**KIRKLEES METROPOLITAN COUNCIL  
INVESTMENT & REGENERATION SERVICE**

**DELEGATED DECISION TO DETERMINE PLANNING APPLICATIONS**

Reference No:	<b>2023/62/91896/E</b>
Site Address:	Poplar House, 35, Old Lane, Birkenshaw, BD11 2LA
Description:	Change use of dwelling to day nursery
Recommending Officer:	Elenya Jackson

**DECISION - REFUSED**

Plan Produced for: Steven Leonard
Date Produced: 24 Jun 2023
Plan Reference Number: TQRQM23175140746453
Scale: 1:500 @ A4

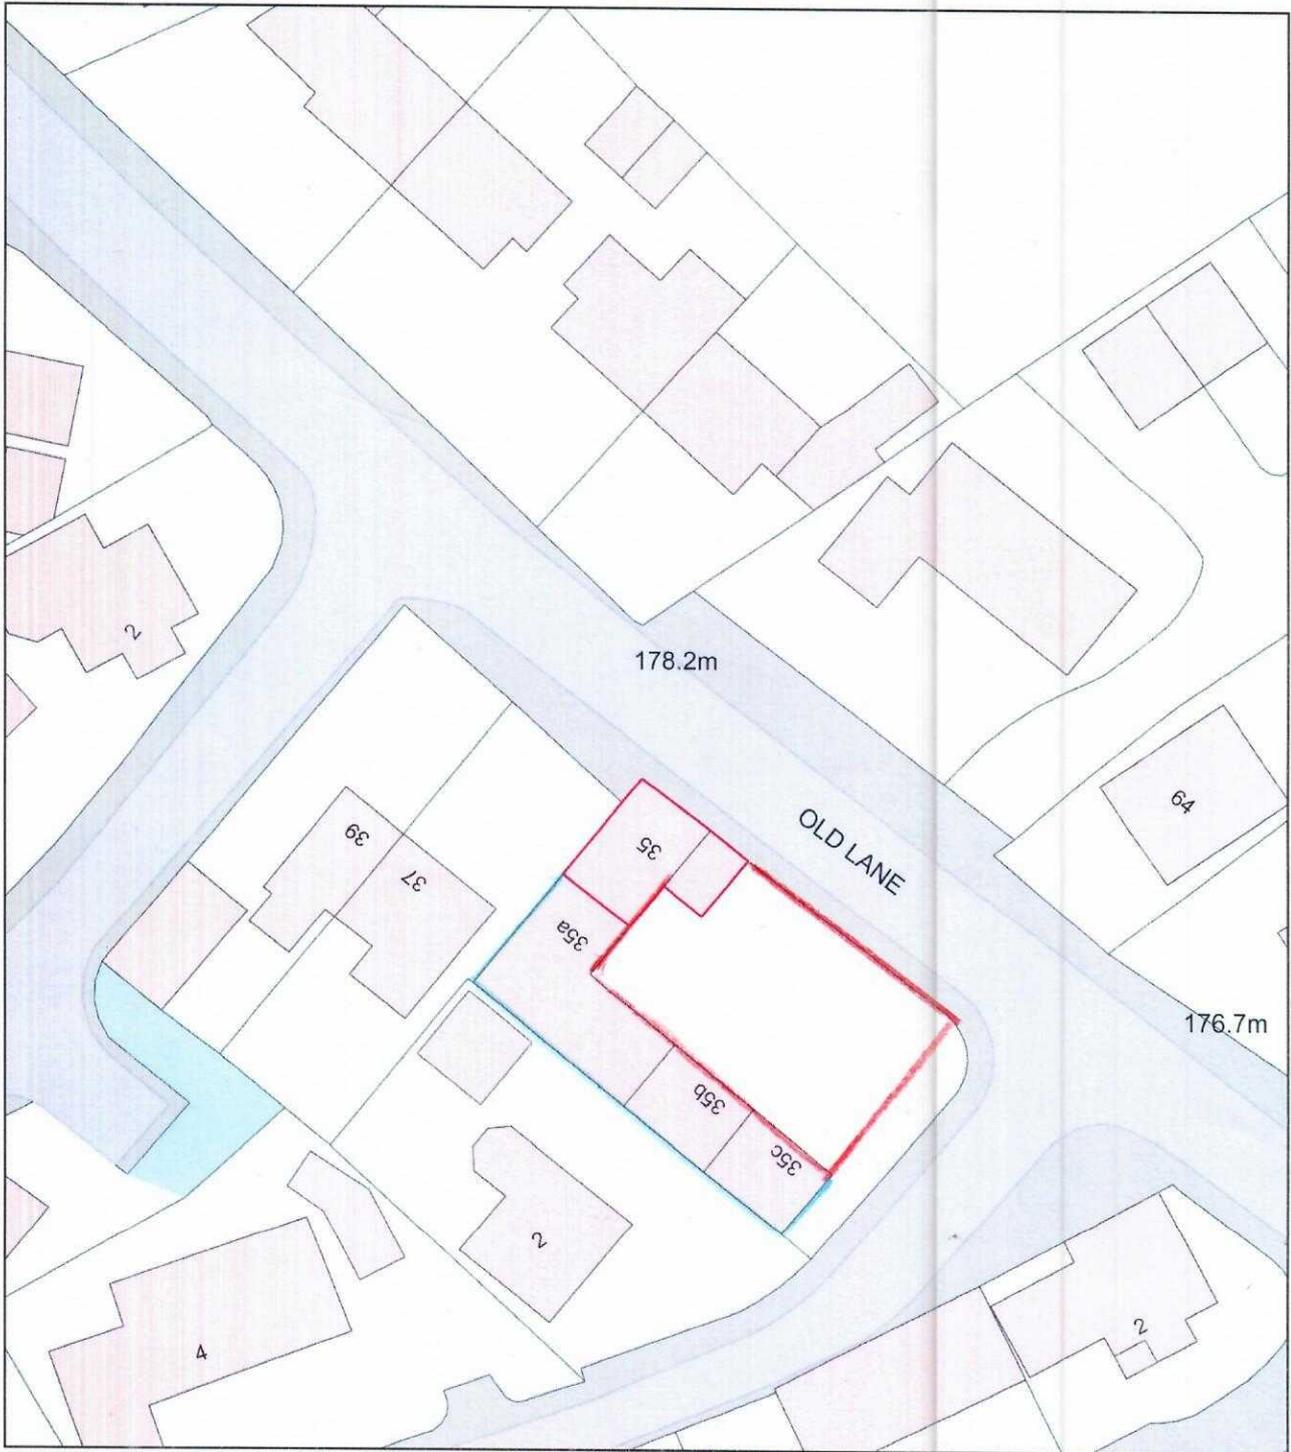
There is no outdoor amenity space indicated on the information provided and due to site layout, officers consider that there is limited scope for sufficient amenity space to be provided which would serve 24 children. Any use of external spaces would result in noise from the site. Furthermore traffic movements associated with the use is likely to result in a loss of amenity to nearby residents and there is no evidence to suggest otherwise.

The comments provided state that Highways cannot support the application as submitted due to clarification of the existing and proposed car park area. Details of eight parking spaces have been provided to support this application; however, these are shared with other properties and not exclusive to the development.

In addition, Details of waste storage and collection for the proposed Nursery should be provided, with the location of a waste collection presentation point being clearly marked on a drawing. however, the application form indicates that the site intends on obtaining commercial bins.

The walls adjacent to the access would need to be lowered to provide for driver/pedestrian intervisibility.
